**DEVELOPMENT HEARING OFFICER
Action Sheet Summary**

August 23, 2023

6. [PR-2022-007589](#)
SD-2023-00157 – FINAL PLAT
IDO – 2021
SKETCH PLAT (DFT): 1-13-23
PRELIMINARY PLAT 2/8/23

REQUEST: INTERIOR LOT LINE ELIMINATION OF 9 PARCELS TO CREATE 2 NEW PARCELS. PLAT ALSO GRANTS 3 NEW EASEMENTS (PUBLIC SIDEWALK AND PUBLIC UTILITY)

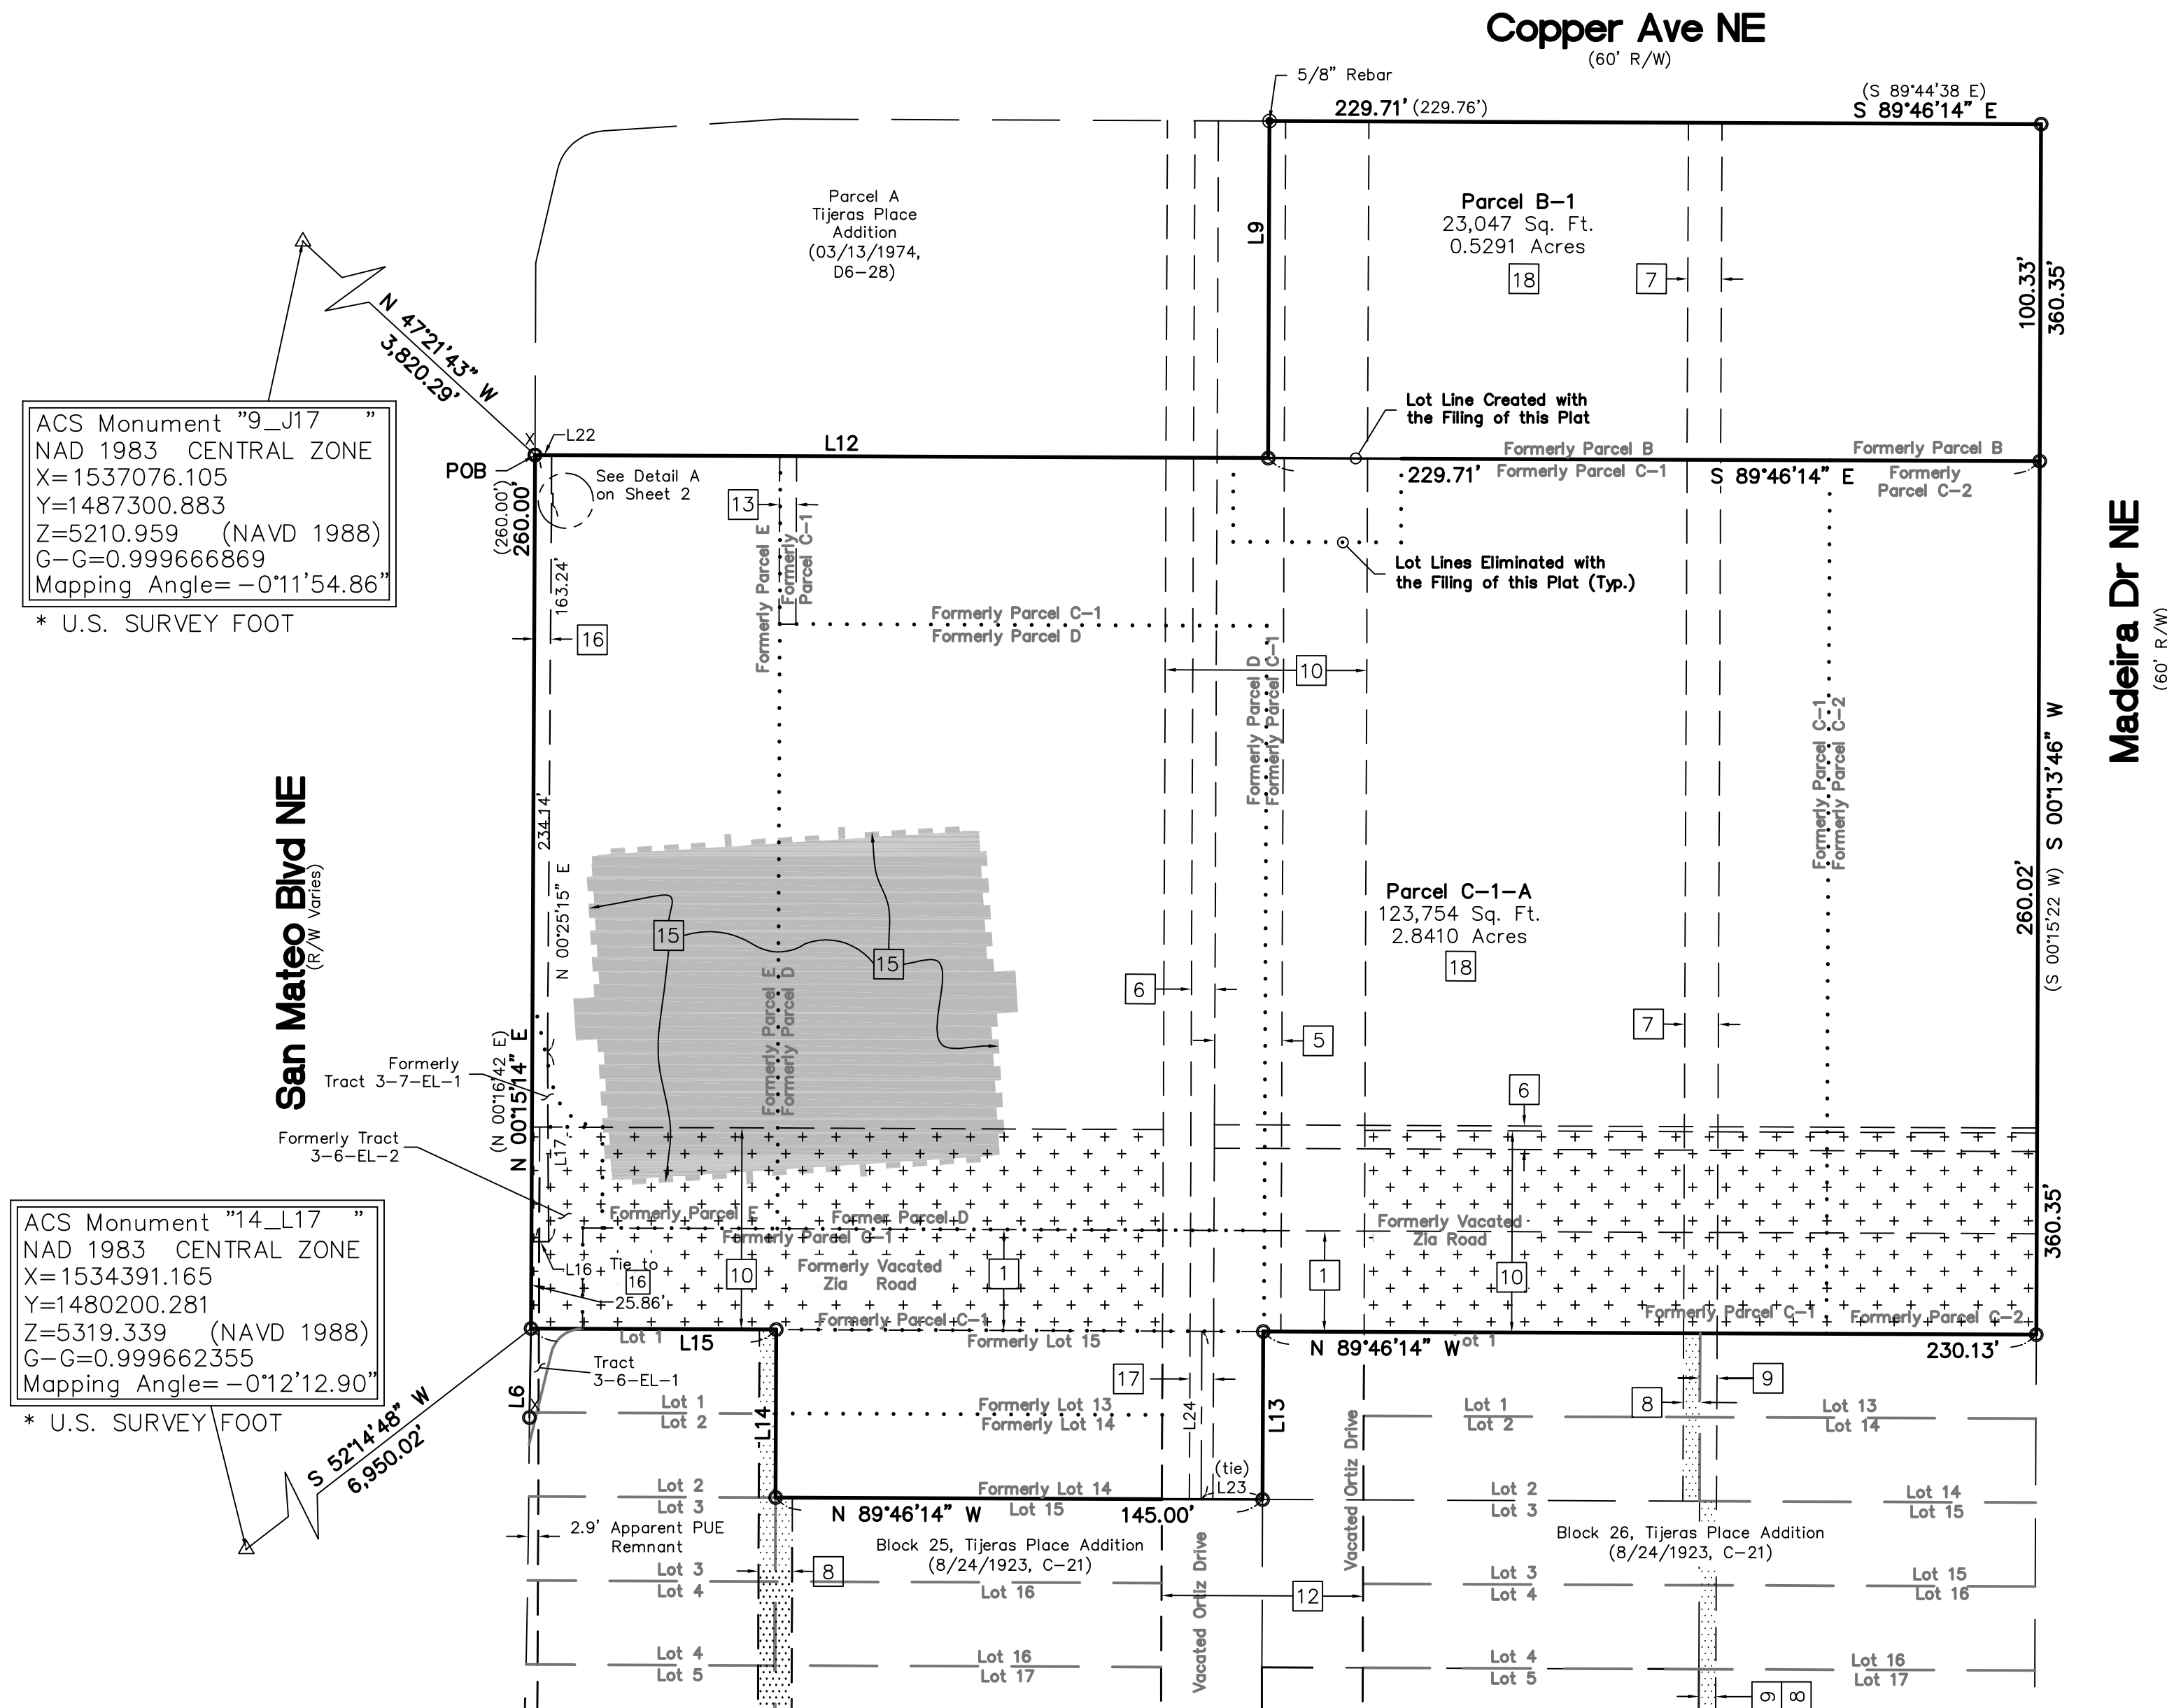
- **PROJECT AND APPLICATION NUMBERS MUST BE ADDED TO THE PLAT**
- **AGIS DXF FILE APPROVAL**
- **THE EXISTING ACCESSORY BUILDING ON THE SITE ENCROACHES ON THE LOT BOUNDARY AND EVIDENCE OF THE DEMOLITION OF THE BUILDING MUST BE SUBMITTED**
- **THE APPLICANT MUST CONTACT PARKS AND RECREATION REGARDING THE RETAINING OF EXISTING TREES**
